Consultation Response from: KC Environmental Health (Pollution & Noise Control)
2025/91531 - Land off Leeds Road, Heckmondwike, WF16 9DB
Demolition of existing semi-detached houses and associated buildings, and construction of 51 dwellings, including associated access and other associated works
Responding Date:
27th August 2025
Responding Officer:
SR & MN
Responding Ref:
WK202524579
Comments
Contaminated Land

### **BOREHOLE AND TRIAL PIT LOCATION PLAN AND LOGS**

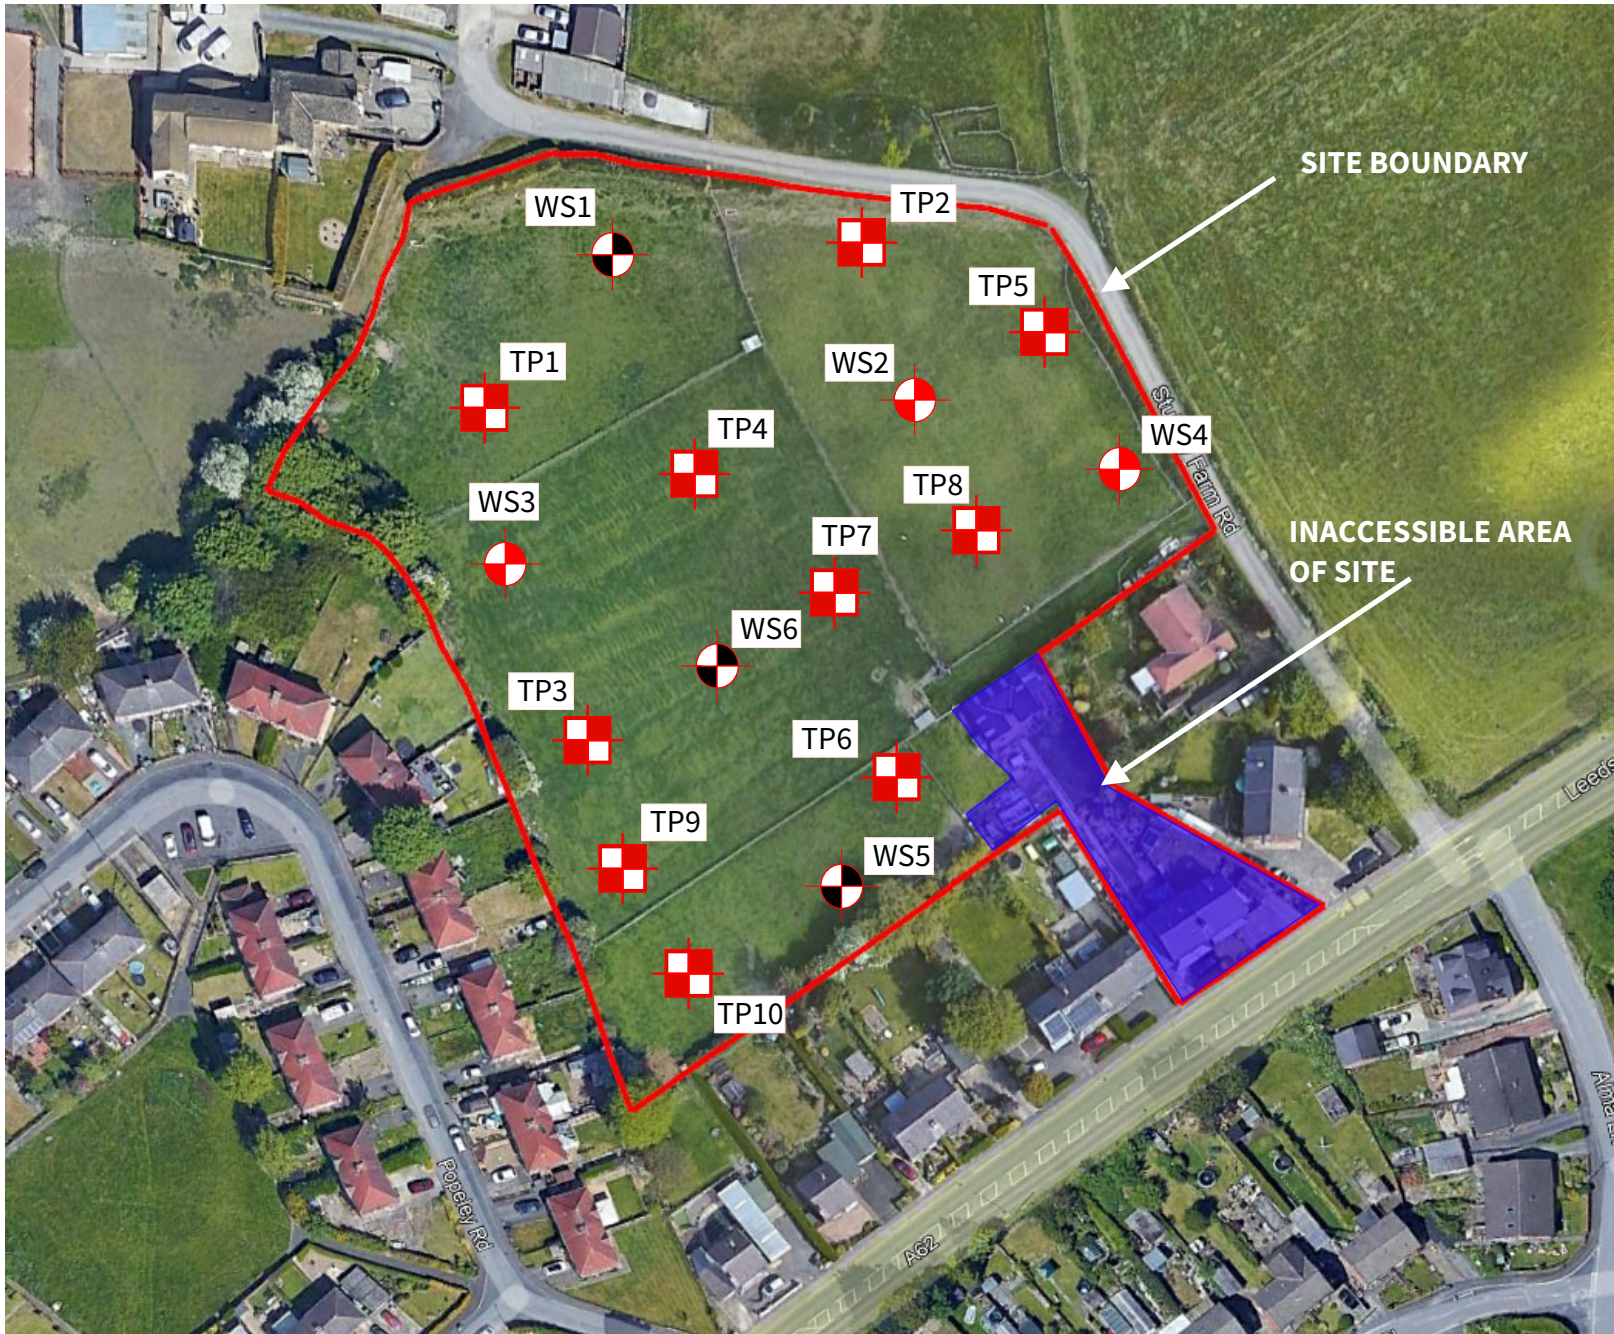
Fieldworks were undertaken on the 17th and 22nd of October 2024 consisting of 10No. trial pits (TP1 to TP10) and 6No. boreholes (WS1 to WS6), to depths of between 1.4m and 3.0m. Gas monitoring wells were installed at locations WS1, WS5 and WS6. The locations of the intrusive investigations are shown in Appendix J.

1 out of 3 topsoil samples have exceedances and 1 in 4 clay samples have exceedances. We disagree with the conclusion that no further assessment or remediation measures are necessary. Numbers of topsoil and clay samples across the site are very limited and we require more robust commentary on the statistical analysis and the justification for the small number of samples across the site. We recommend further sampling be undertaken to support the conclusions reached.
